THE TRAILS AT ASPEN RIDGE FILING NO.1A

Final Plat_V1.pdf Markup Summary

**THE TRAILS AT ASPEN RIDGE FILING NO.14**  
A SUBDIVISION OF A PORTION OF THE WEST 1/2 OF SECTION 9,  
TOWNSHIP 15 SOUTH, RANGE 65 WEST OF THE 6TH P.M.,  
EL PASO COUNTY, COLORADO  
SHEET 1 OF 3

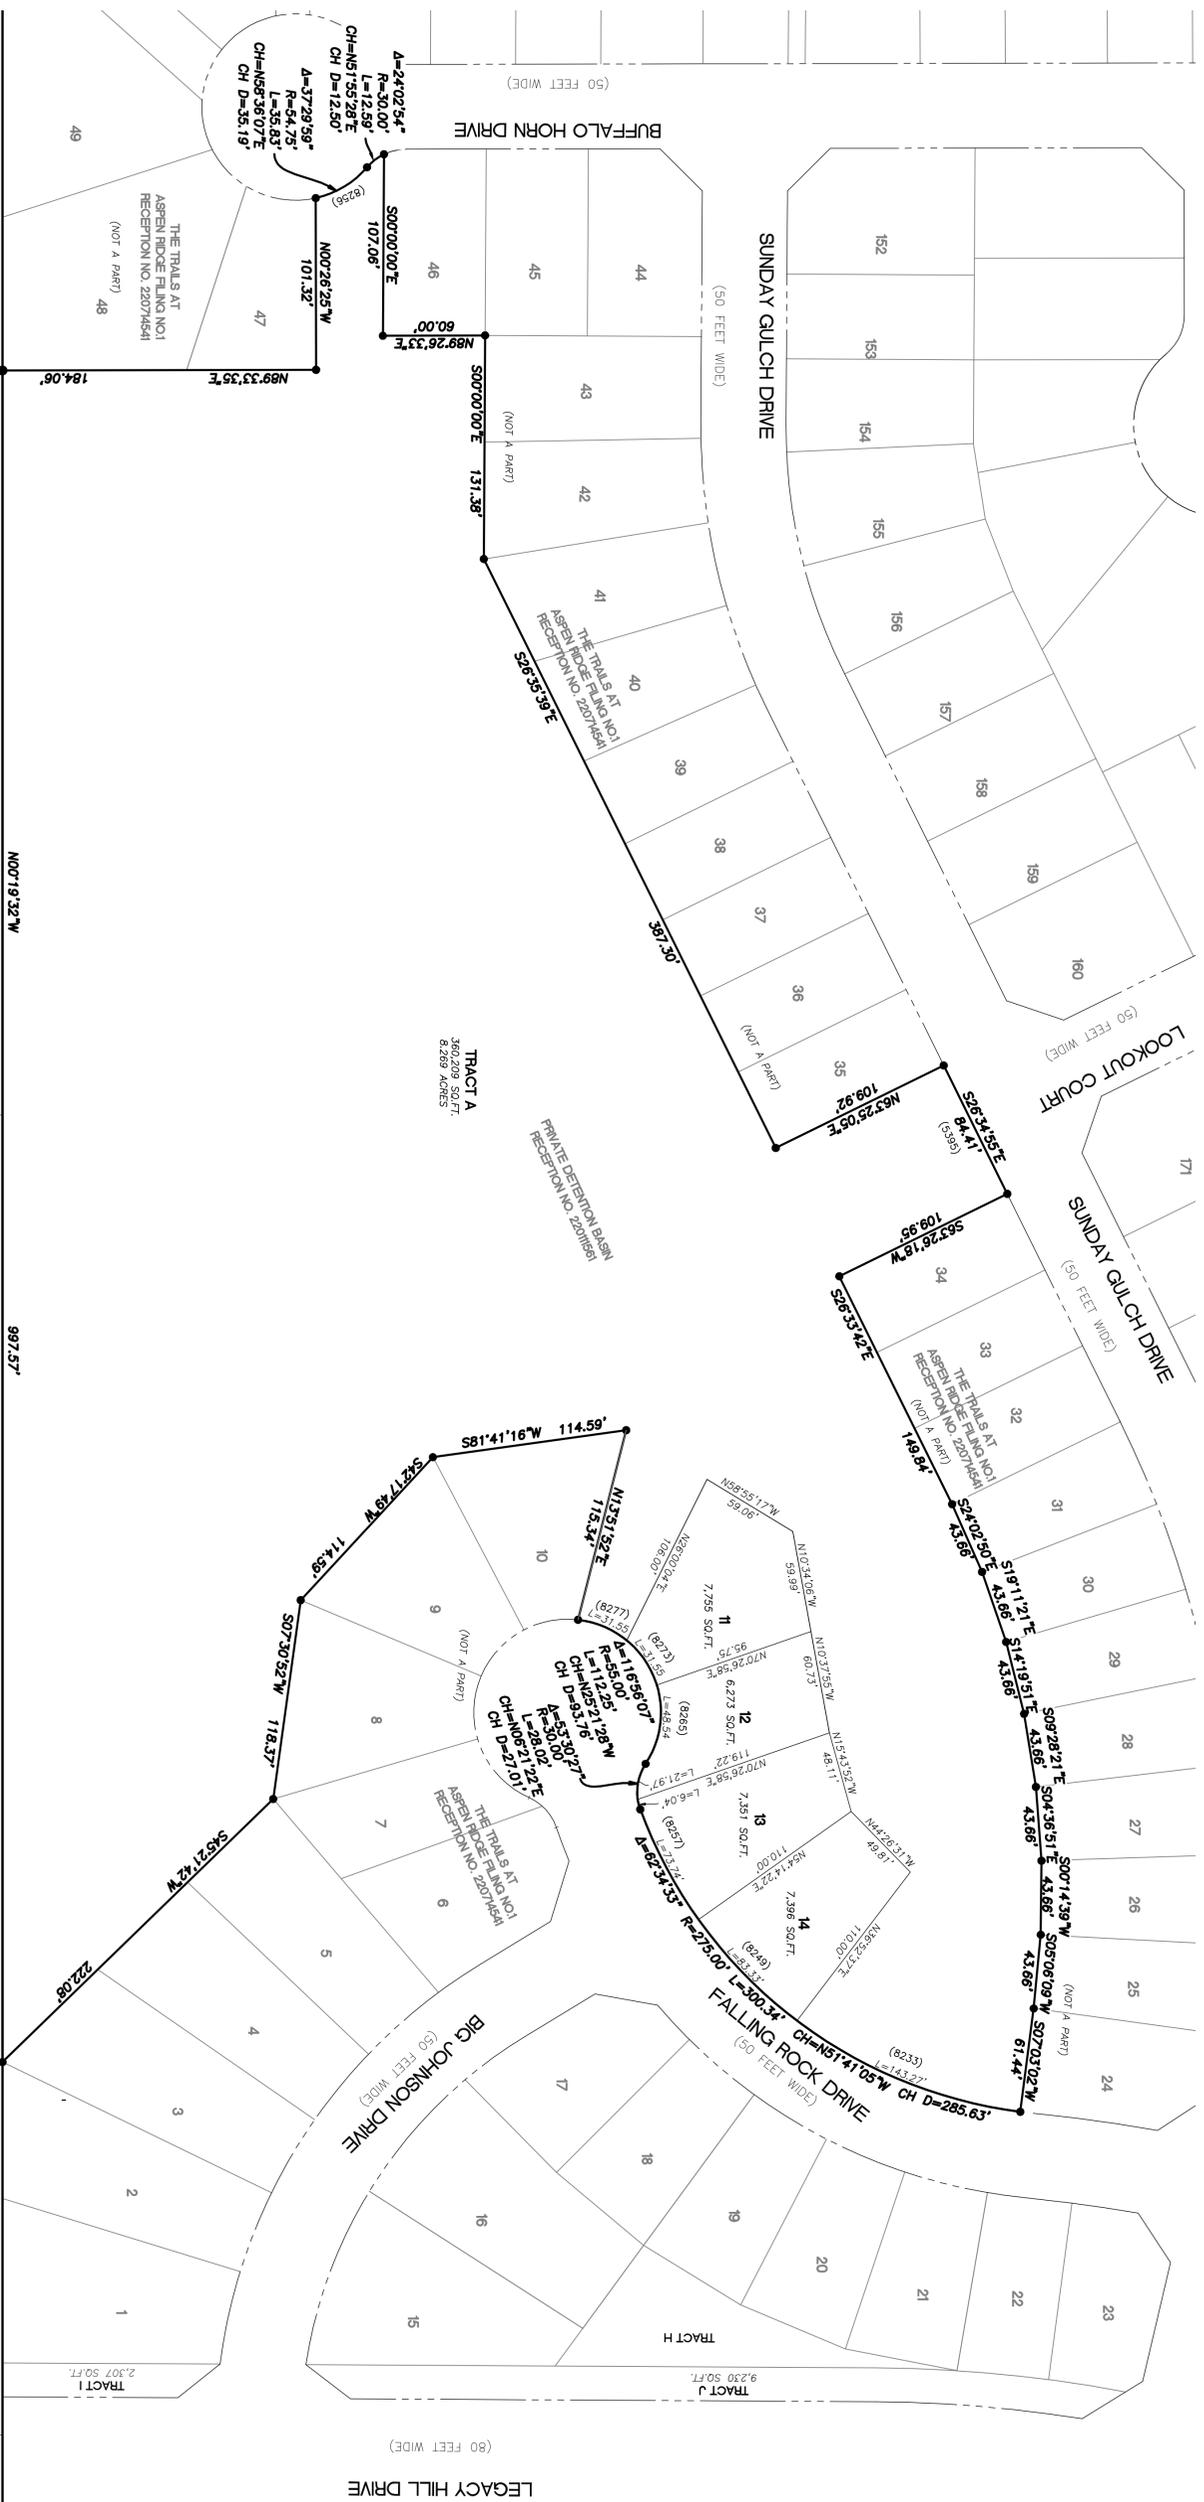
Add "PCD File No. VR-21-02".

Should this read "Filing No. 1" instead of 1A?

Revise to "El Paso County Planning & Community Development Department"

Revise to "El Paso County Planning & Community Development Department"

Revise to 14 instead of 114.

remove 'onto a County roadway', as current standards require any and all driveways to be permitted via access permit.

Add "recording" for recording fee

Please use standard Owners Certificate:

Reception no.?

Revise to use language of this standard note:
Public and Common Subdivision Improvements:
No lot or interest therein, shall be sold, conveyed, or transferred whether by deed or by contract, nor shall building permits be issued, until and unless either the required public and common development improvements have been constructed and completed and preliminarily accepted in accordance with the Subdivision Improvements Agreement between the applicant/owner and El Paso County as recorded under Reception Number _____ in the Office of the Clerk and Recorder of El Paso County, Colorado or, in the alternative, other collateral is provided to make provision for the completion of said improvements in accordance with the El Paso County Land Development Code and Engineering Criteria Manual. Any such alternative collateral must be approved by the Board of County Commissioners or, if permitted by the Subdivision Improvements Agreement, by the Planning and Community Development Department Director and meet the policy and procedure requirements of El Paso County prior to the release by the County of any lots for sale, conveyance or transfer.

Mailboxes:
Mailboxes shall be installed in accordance with all El Paso County and United States Postal Service regulations.

A SUBDIVISION OF A PORTION OF THE WEST 1/2 OF SECTION 9,  
TOWNSHIP 15 SOUTH, RANGE 65 WEST OF THE 6TH P.M.  
EL PASO COUNTY, COLORADO  
SHEET 3 OF 3

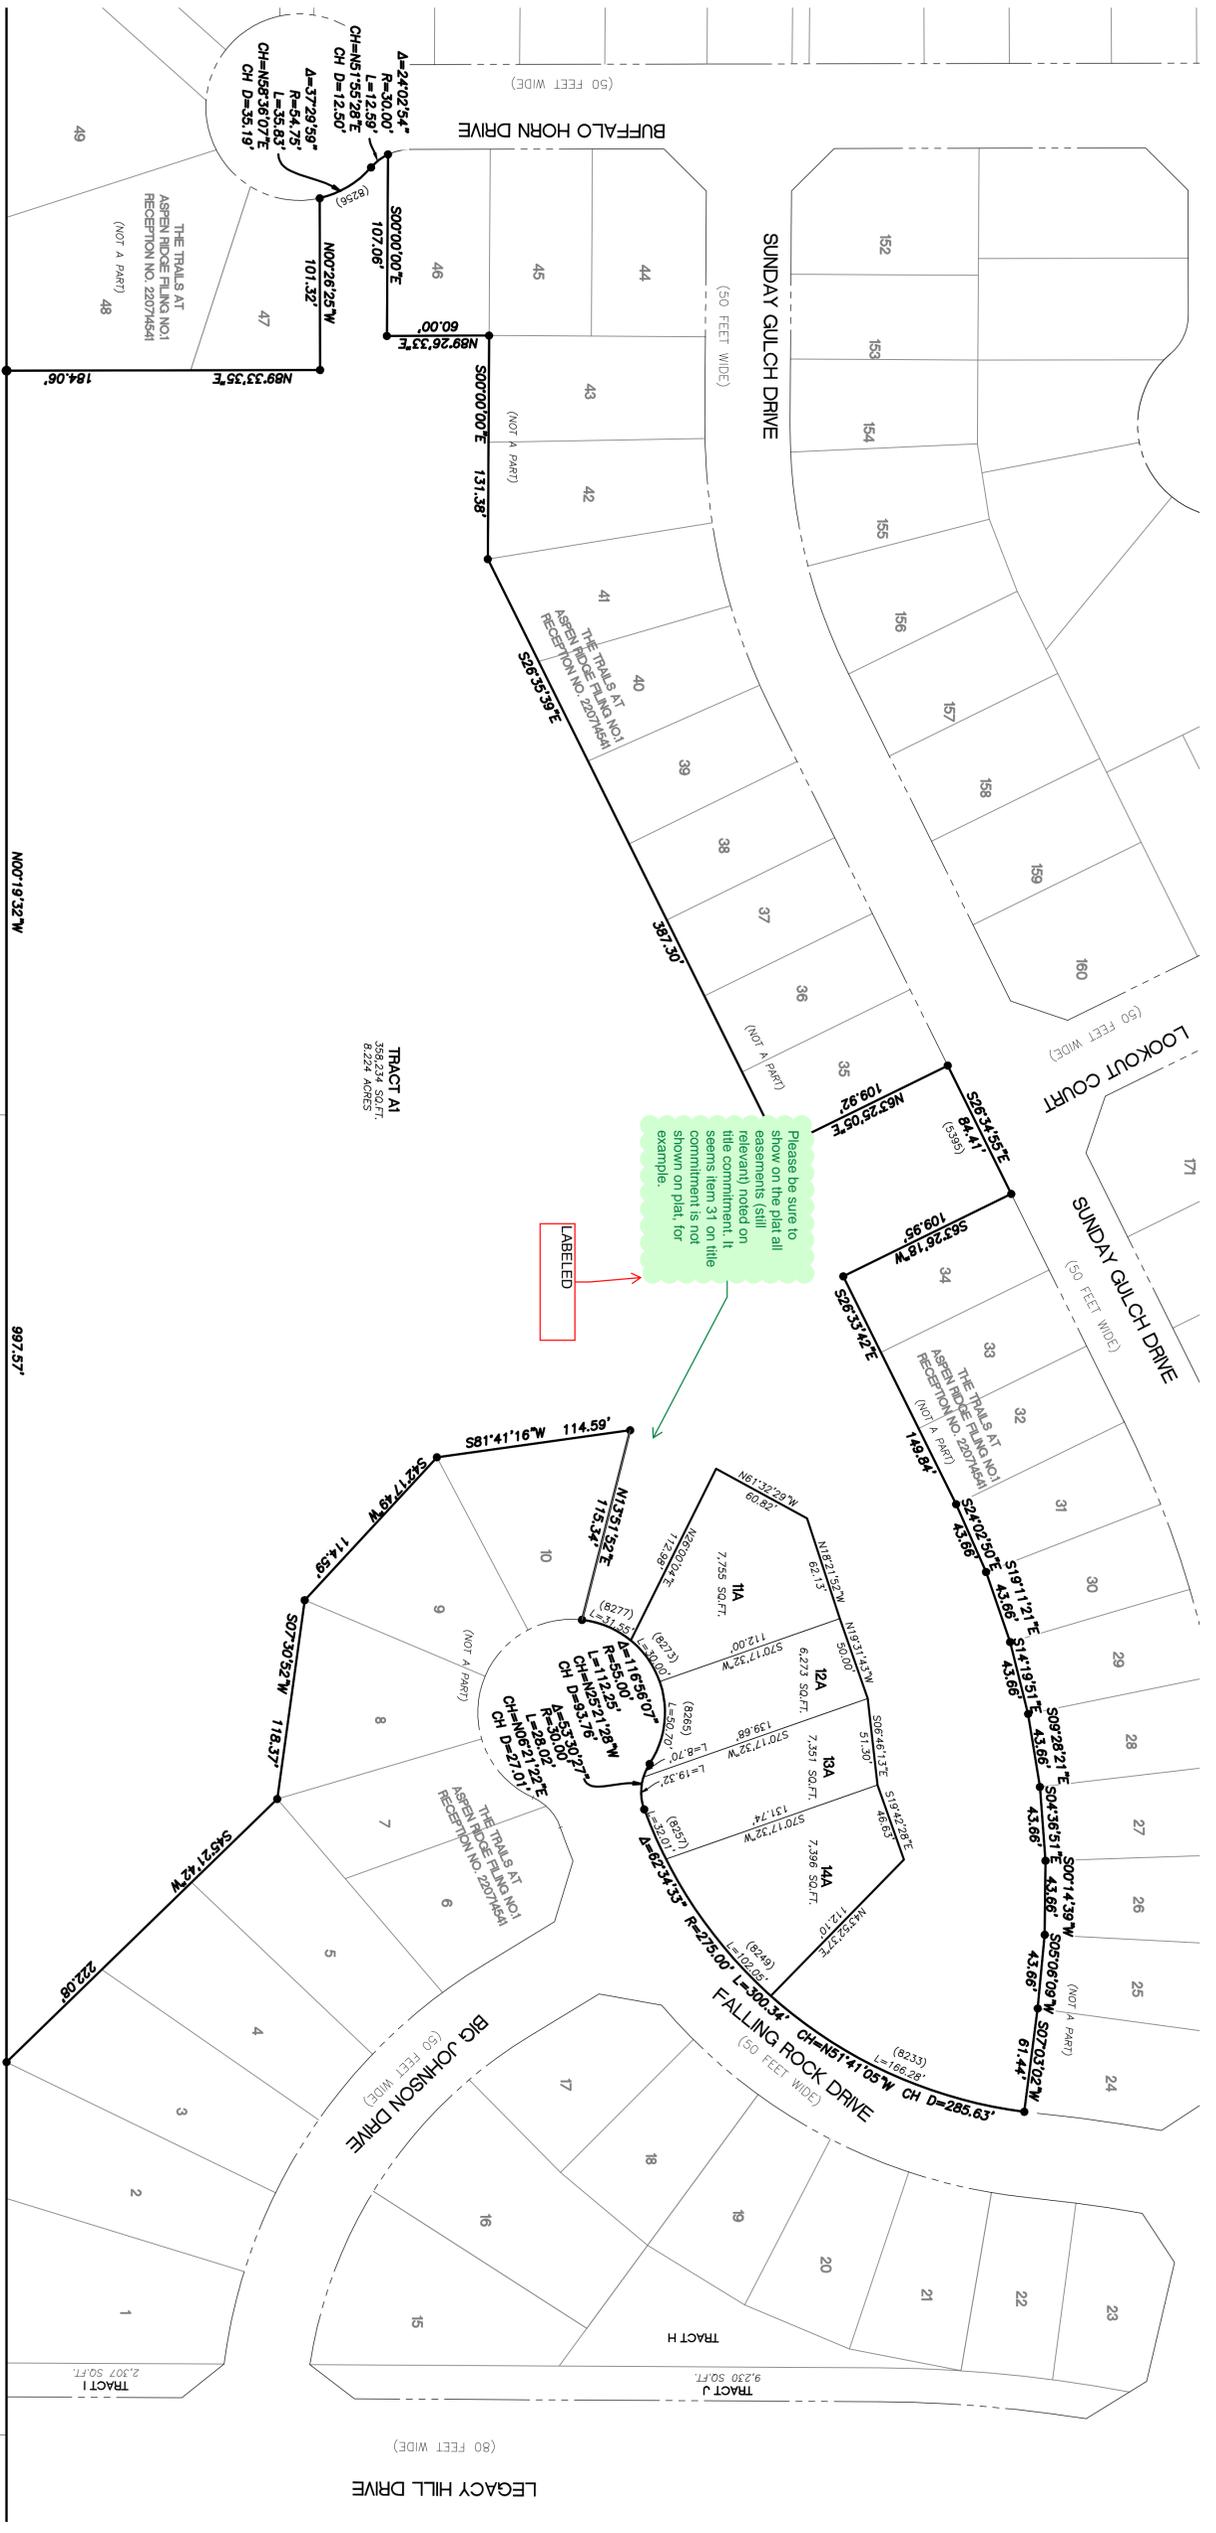
Please be sure to show on the plat all easements (still relevant) noted on title commitment. It seems item 31 on title commitment is not shown on plat, for example.
